From: Sarah Fawdry [REDACTED]
Sent: 02 March 2023 15:55
To: Jessica Riches; David Easton
Cc: Chris Brake; Katie Martin; Martin Kempshall; Thomas Richards; Silvie Steiningerova
Subject: Bilsham Road, Yapton - Y/70/22/DOC and Y/34/22/DOC
Attachments: 2023 02 08 Y 70 22 DOC Drainage Response.pdf; D1956-13-200B Proposed Levels Layout.pdf; D1956-13-201B Proposed Levels Layout.pdf; D1956-13-202B Proposed Levels Layout.pdf; D1956-13-300B Proposed Permeable Paving Formation Levels.pdf; D1956-13-301B Proposed Permeable Paving Formation Levels.pdf; D1956-13-302B Proposed Permeable Paving Formation Levels.pdf

Having recently picked up comments on your online portal regarding Y/70/22/DOC (dated 8 February 2023; attached for ease), please find our responses to the outstanding queries as follows. For ease and completeness, I have followed on from the previous queries with our responses, our latest response is detailed in green.

Rev. A

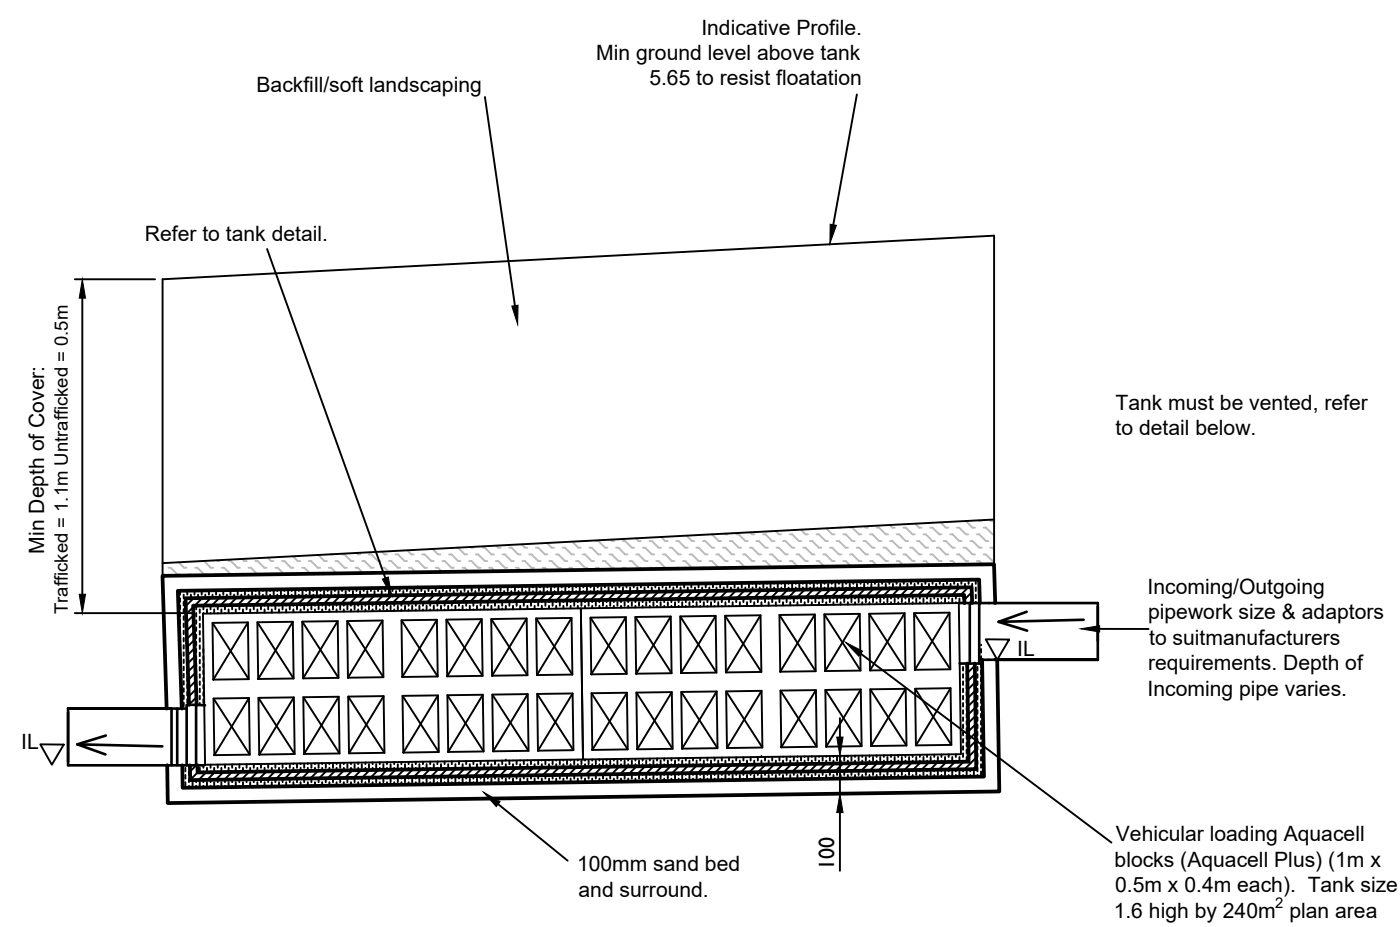
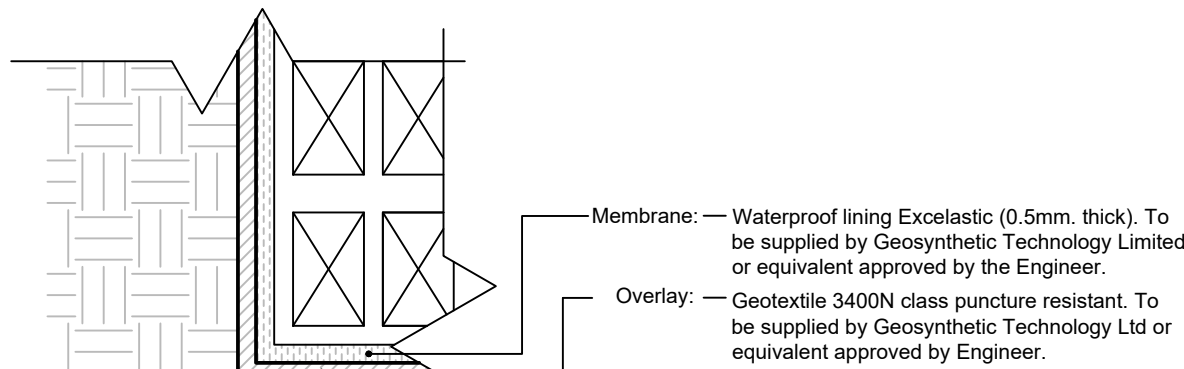
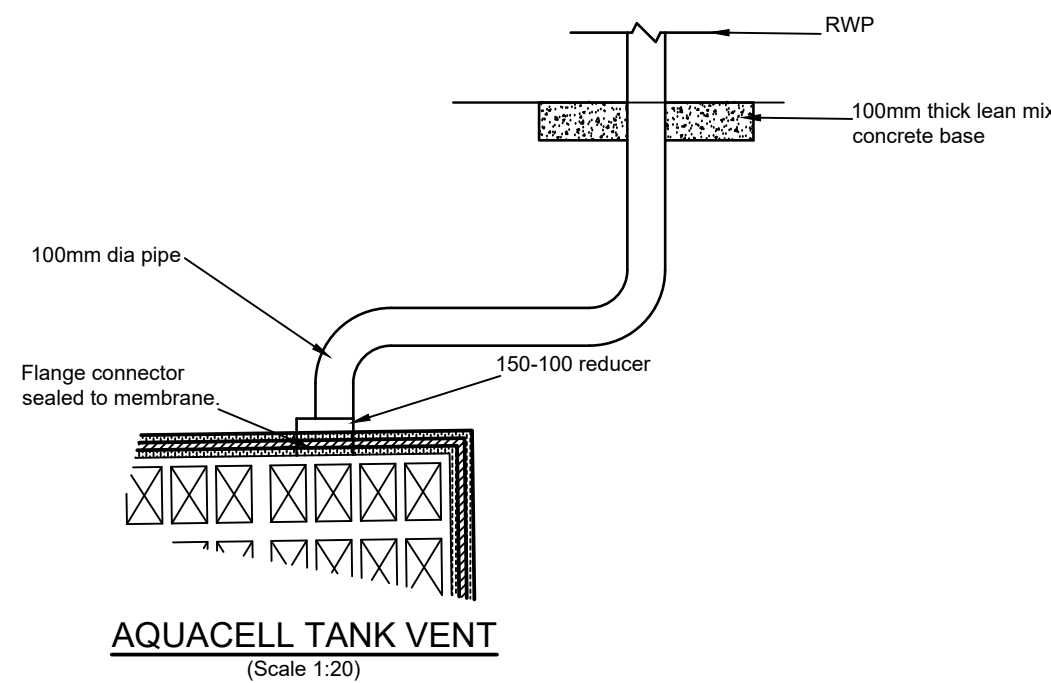
13. There are inconsistencies between layout and details for the attenuation tank. Layout states a depth of tank of 1.5m but detail states a depth of 1.6m. Please ensure consistency. The calculations still state 1.5m . Please also resubmit the construction details for this tank as part of this discharge application 08/2/2023- This has now been received and we have no further comments. TH: RESOLVED No further action required

Drawing No.	D1956-15.20	Rev.	-
-------------	-------------	------	---

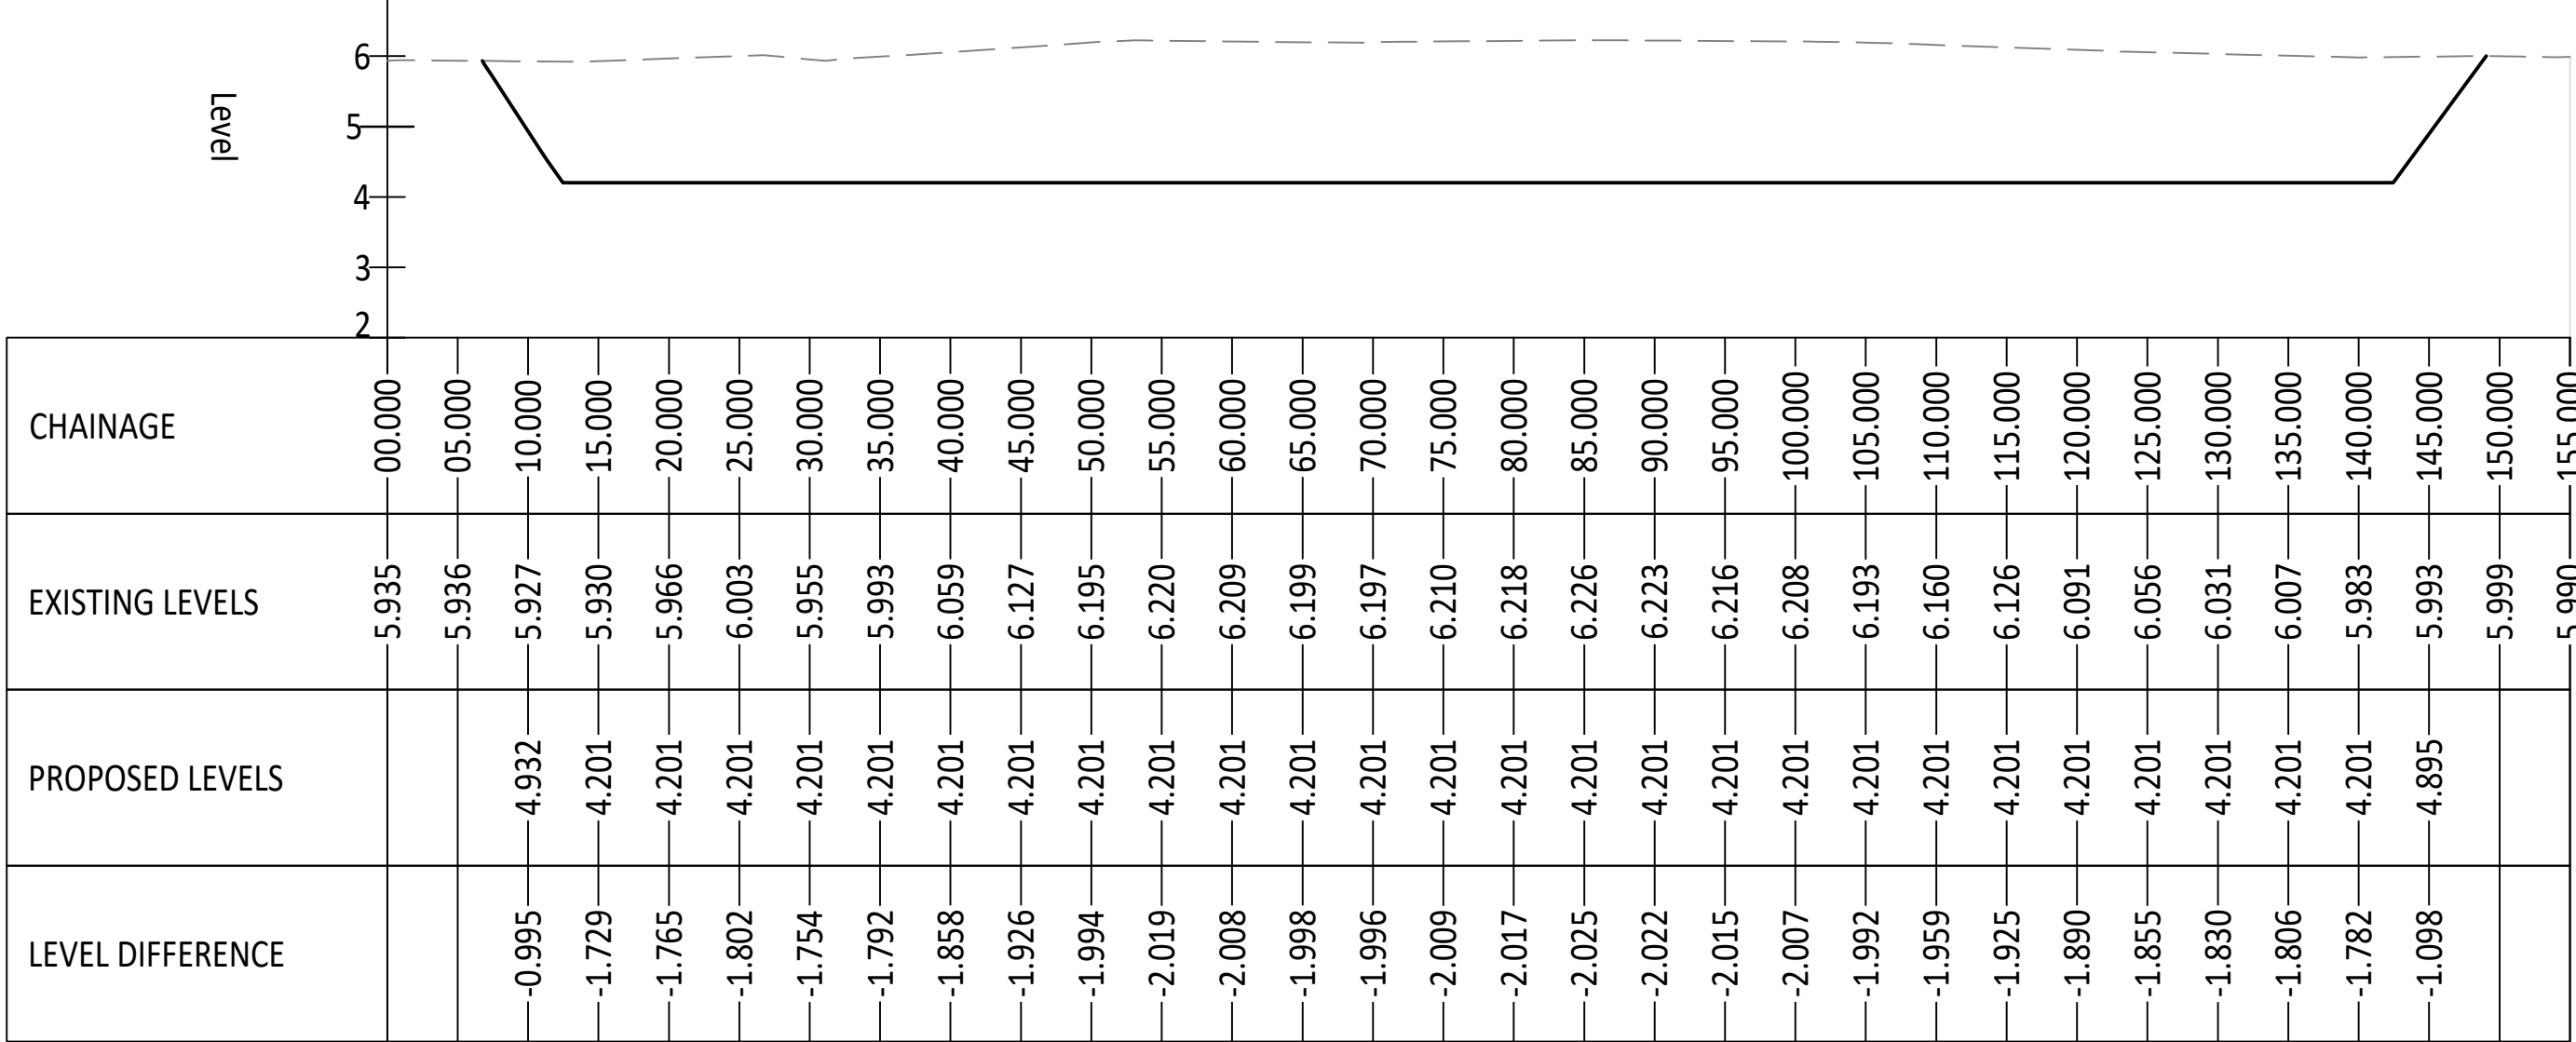
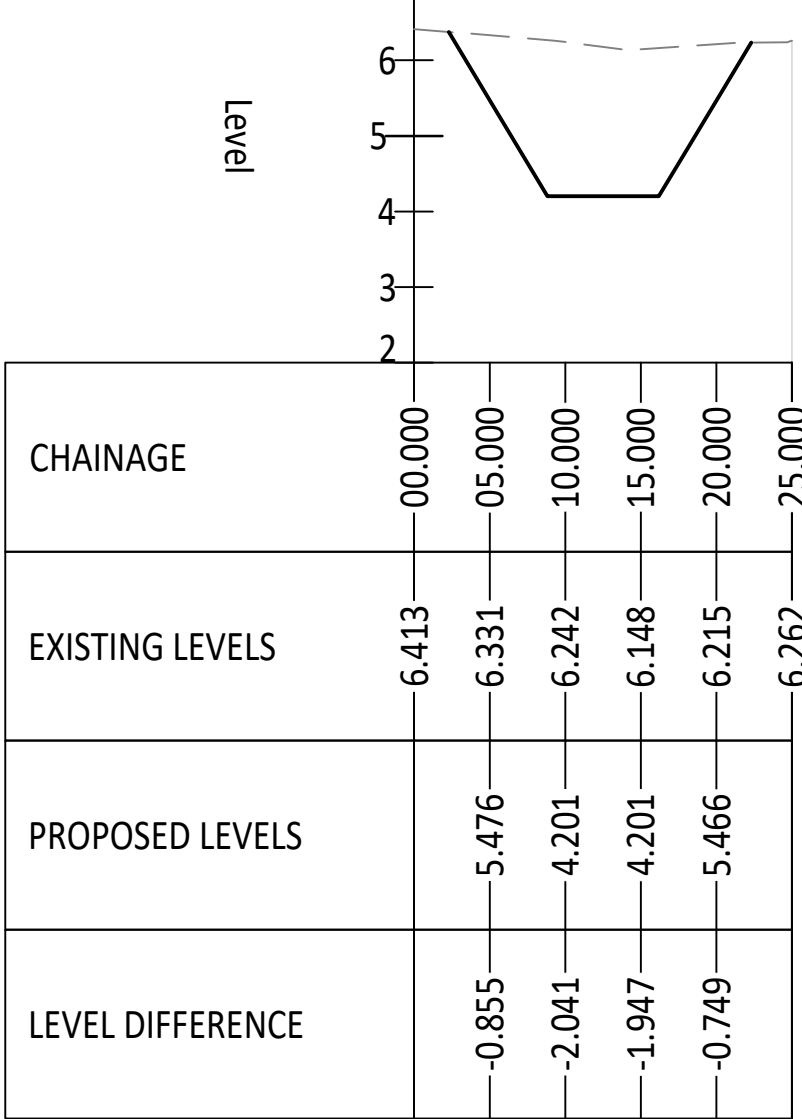
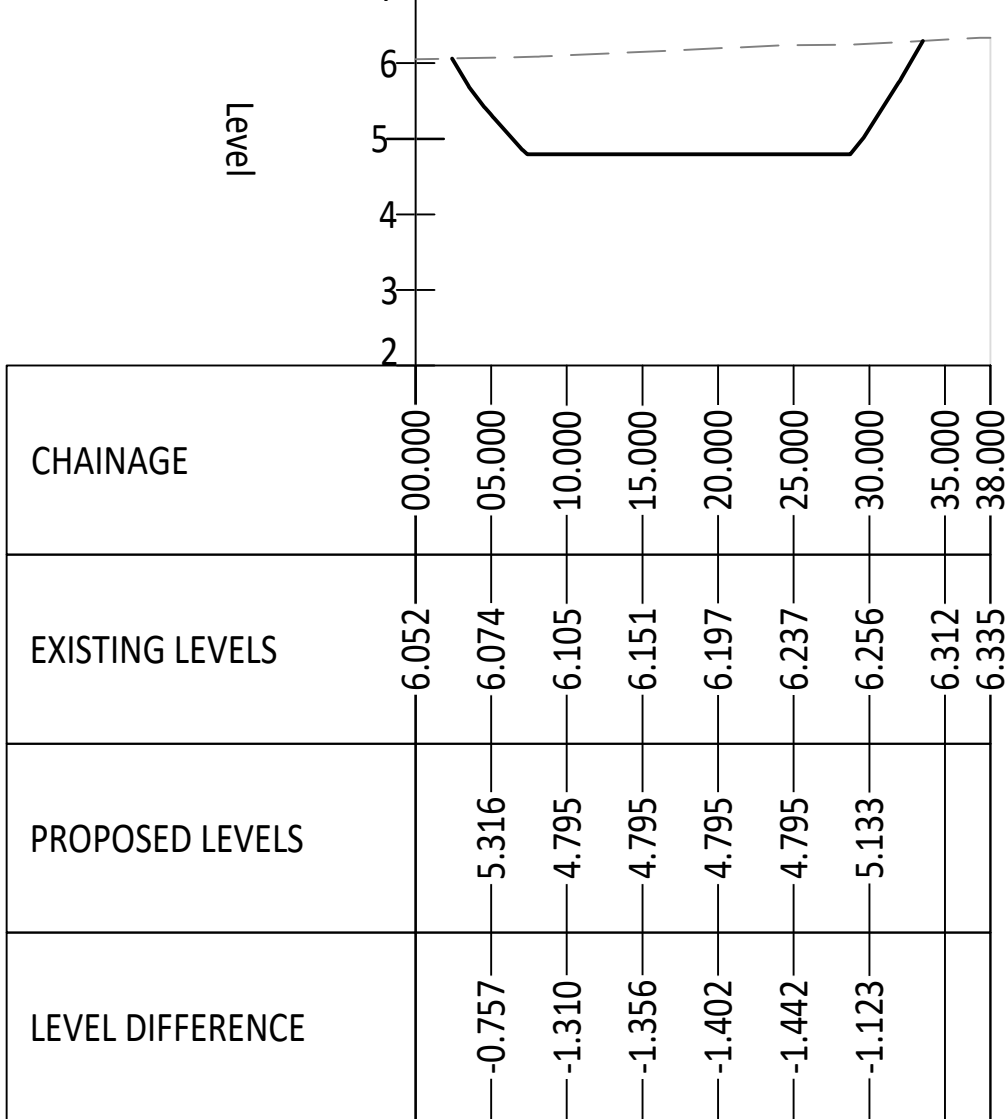
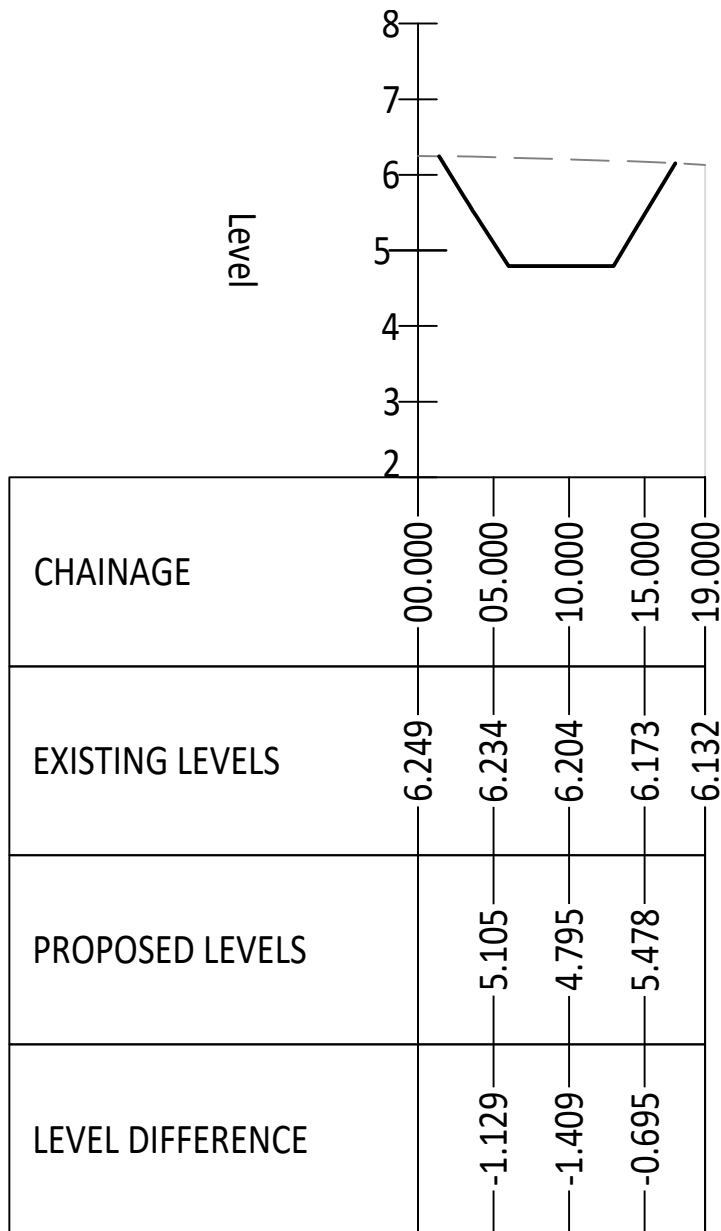
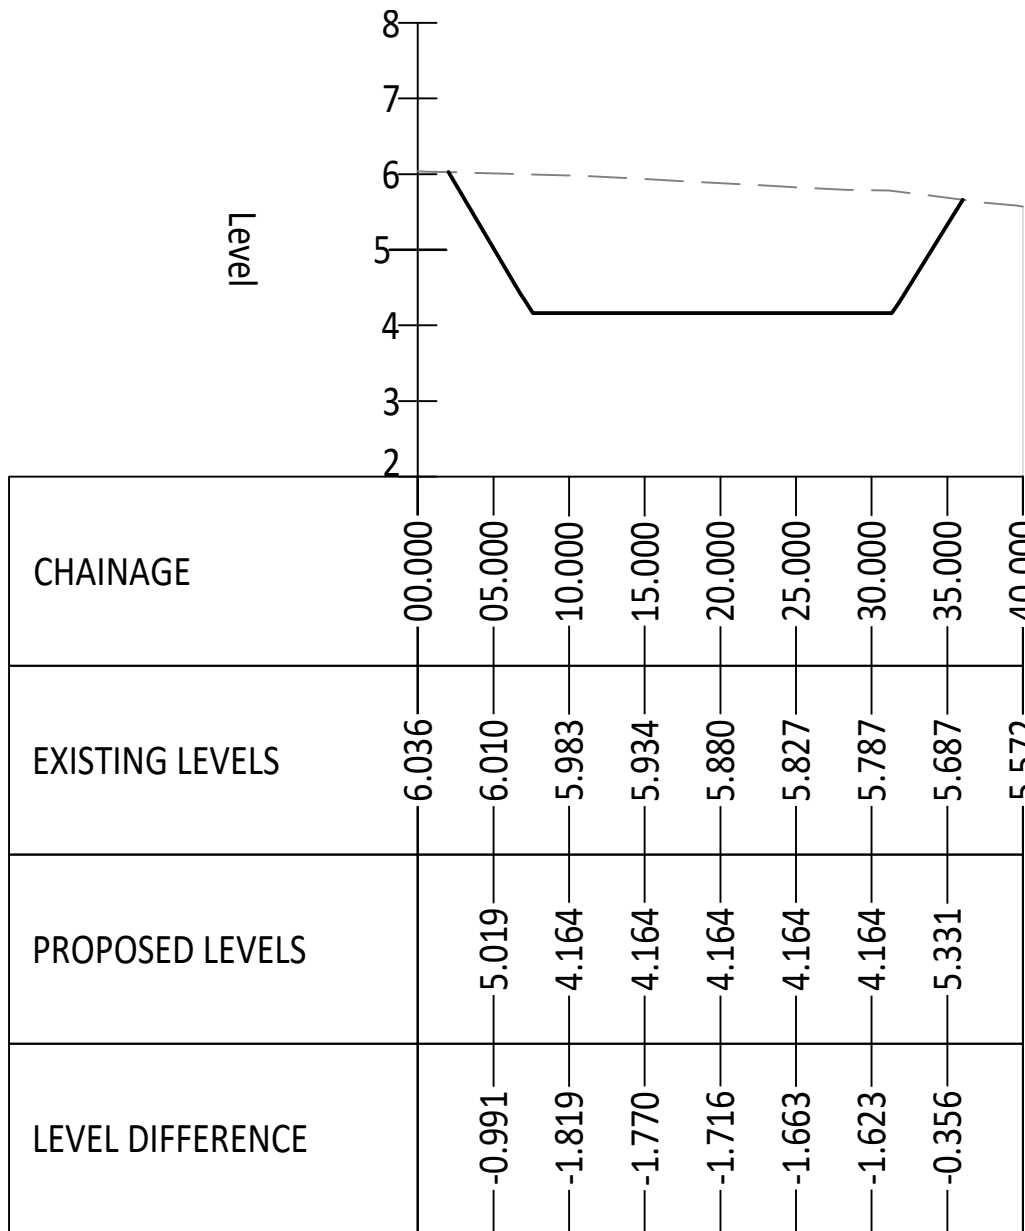
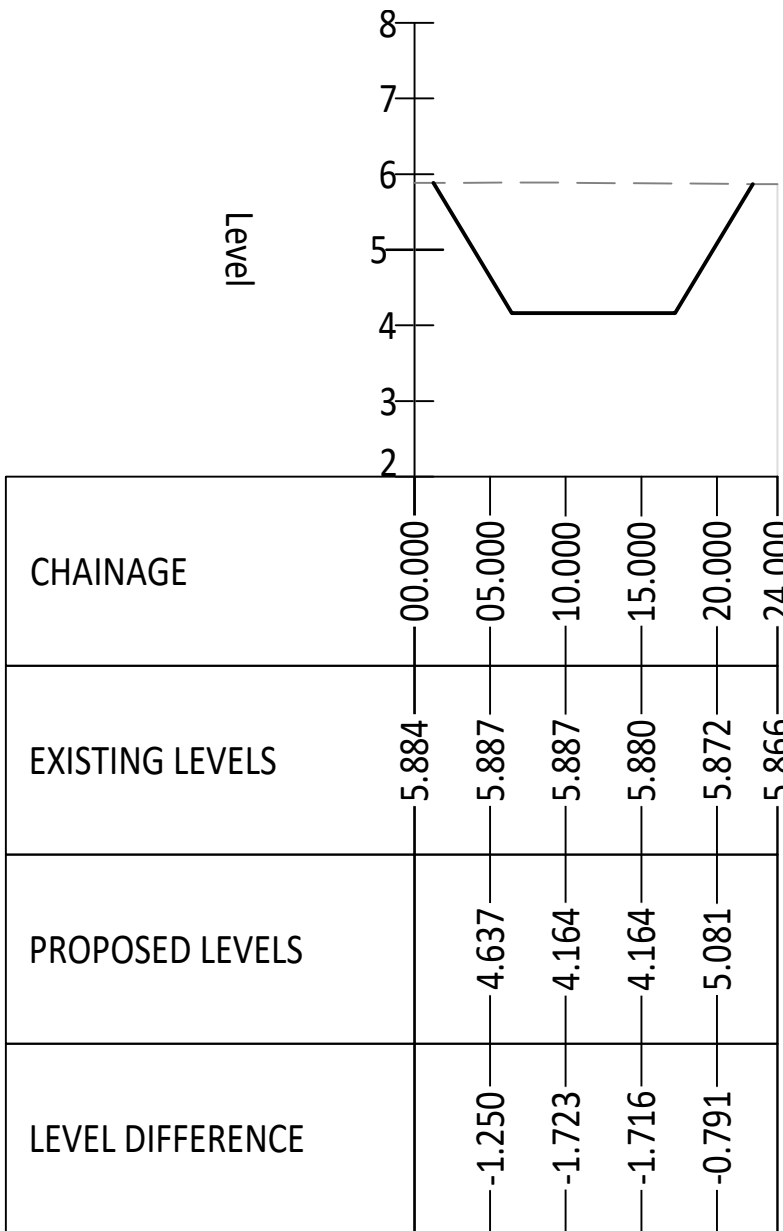
22. *Please provide flotation calculations for cellular storage. It's noted that the buoyancy calculations require the basins to be lined with backfilled which varies across the basins. Specific construction details for each basin clearly providing this corresponding depth of backfill information needs to be provided in the basin construction details. 08/2/2023- No*

24. *Please provide construction detail drawings of basins which clearly show required depths of topsoil and clay over liner which tally with flotation calculations. These details should show invert level, peak water level, and top of bank level of each basin, along with bank slope. Two perpendicular details per basin should be provided. Appreciate cross-sections are provided on drawing D1956-15.22 but these do not clearly define the depths of clay, topsoil make up over the liner. A construction level of detail is being requested. 08/2/2023- No further comment as it is noted that this OWC has now been granted* TH: RESOLVED No further action required

further comment as it is noted that this OWC has now been granted TH: RESOLVED No further action required
